Our Ref: K/29/17/PL 16-08-2017

Demolition of existing dwelling to create 1 No. new dwelling.

14 Coastal Road Kingston

Thank you for your internet representation made on 25th September 2017 which has been recorded as '**an objection**' with the comments as follows:

DRAWING
PROPOSED SITE PLAN

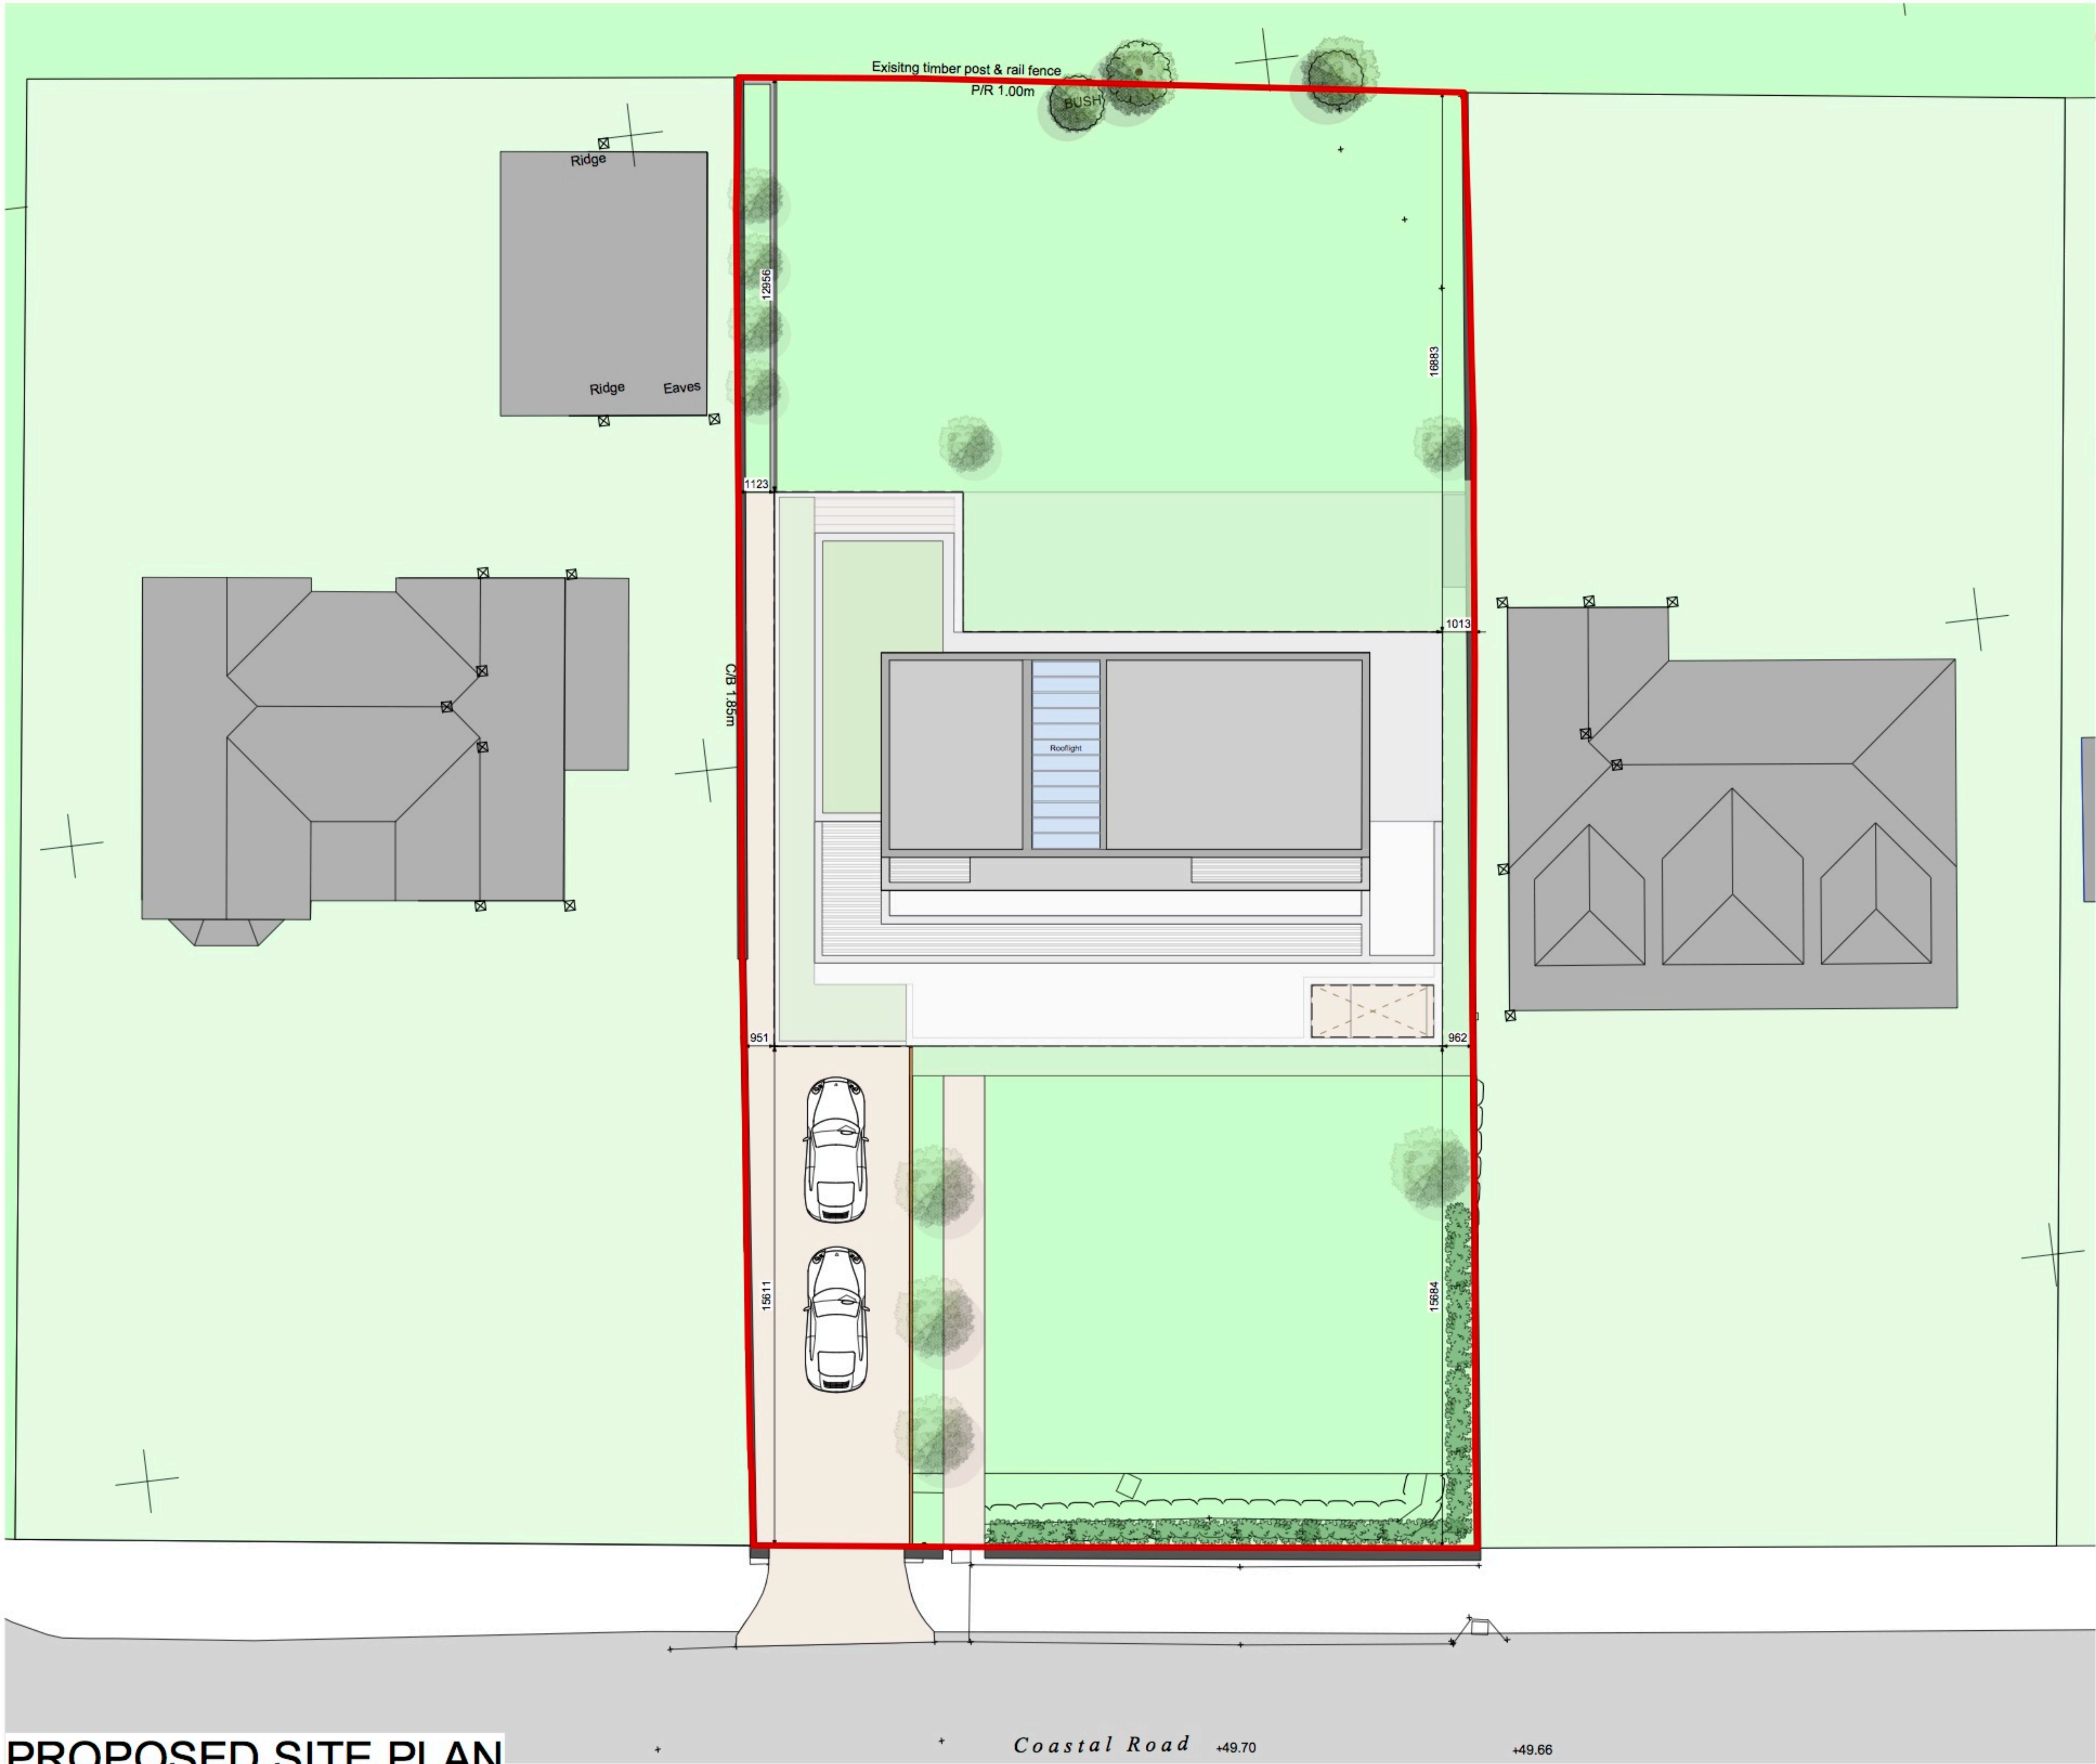
1) The distance between the new house and our boundary wall. We do not consider that this distance should be measured to our house wall, but rather our boundary wall. This new proposal in fact brings our houses closer together. This is unlikely to be in either of our interests.

REV.	DATE	DESCRIPTION
PROJECT		
14 COASTAL ROAD EAST PRESTON BN16 1SJ		
DRAWING		
PROPOSED WEST & NORTH ELEVATIONS		
CLIENT		
MRS & MR CLARKE		
SCALE		DRAWN
1:50 @ A1 / 1:100 @A3		
DATE		CHECK
JUNE 2017		
DRAWING No.		REVISION
1714- PL1-10		C
© copyright retained

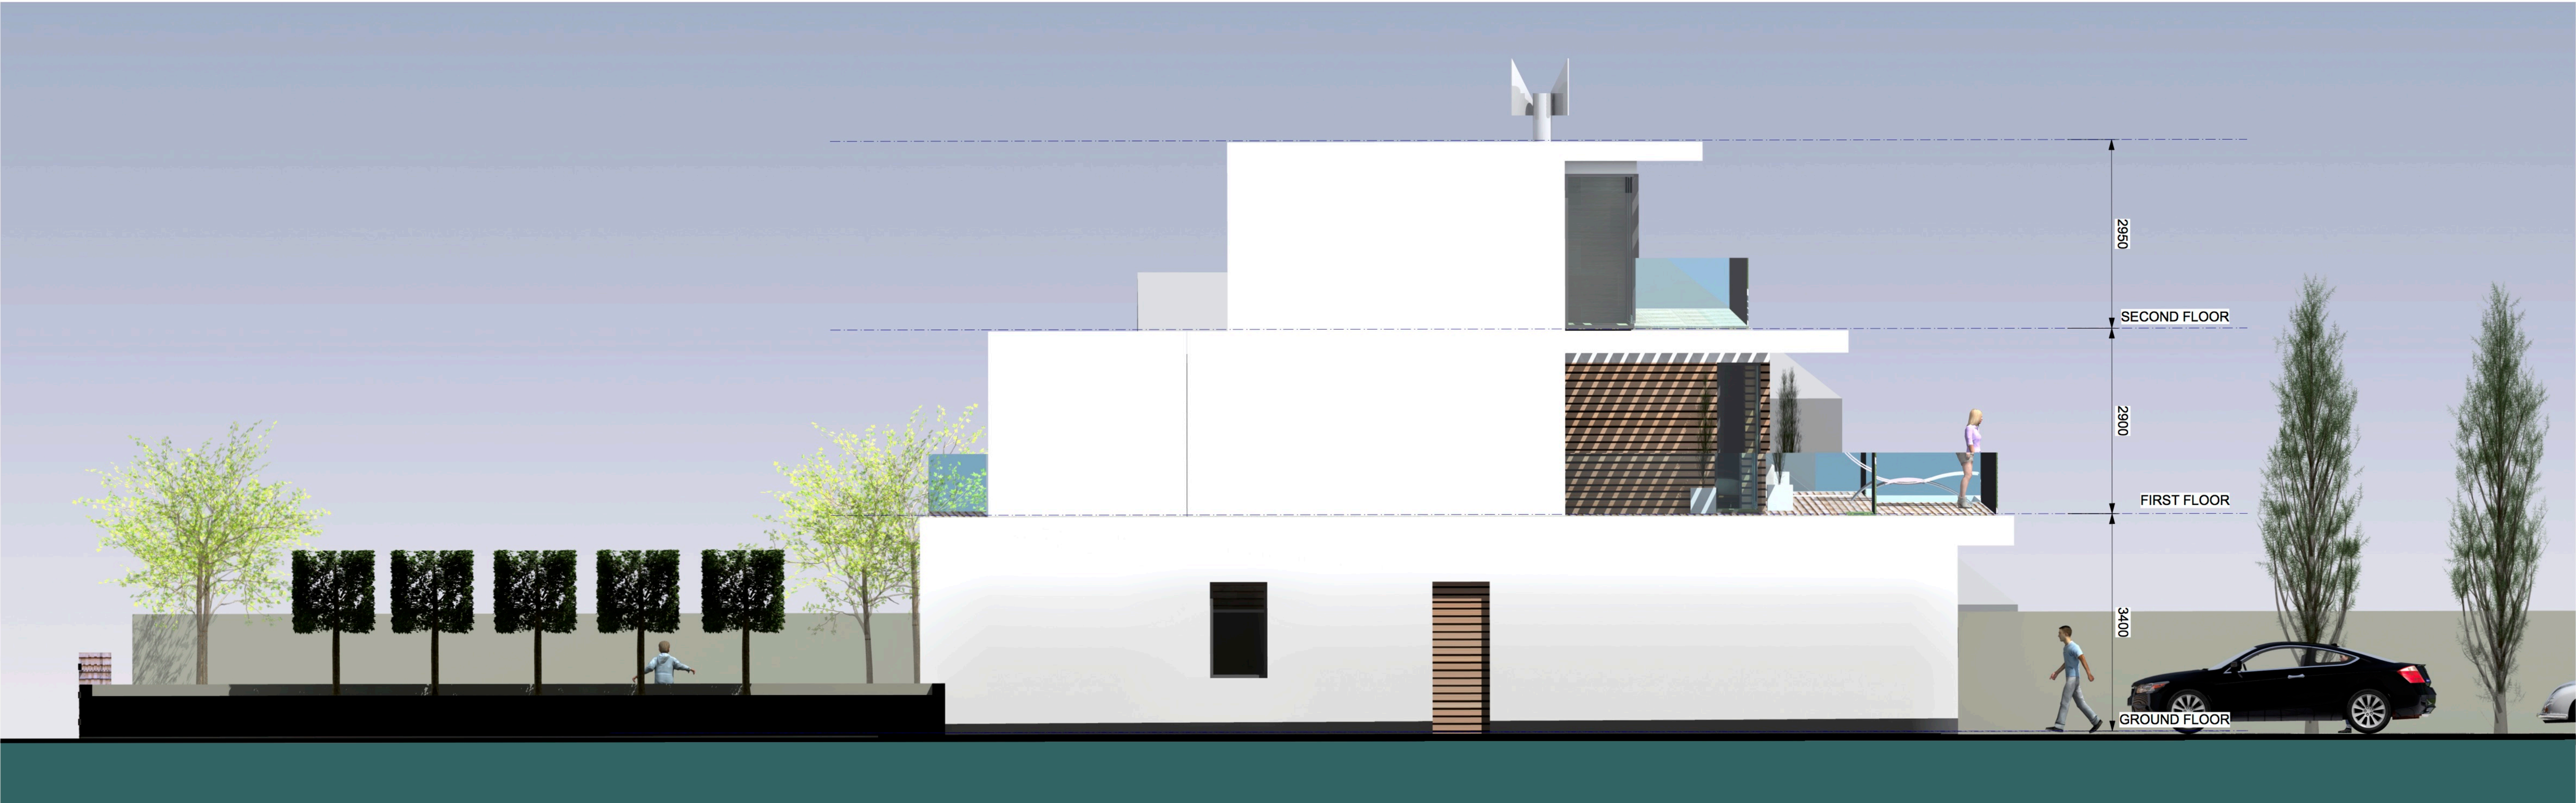
2) We are concerned that the balconies (particularly a new second floor terrace) will cause our garden to be overlooked and impinge on our privacy. Whilst there is already a balcony on the first floor, we do not think that the privacy we should be afforded in our garden has been adequately addressed.
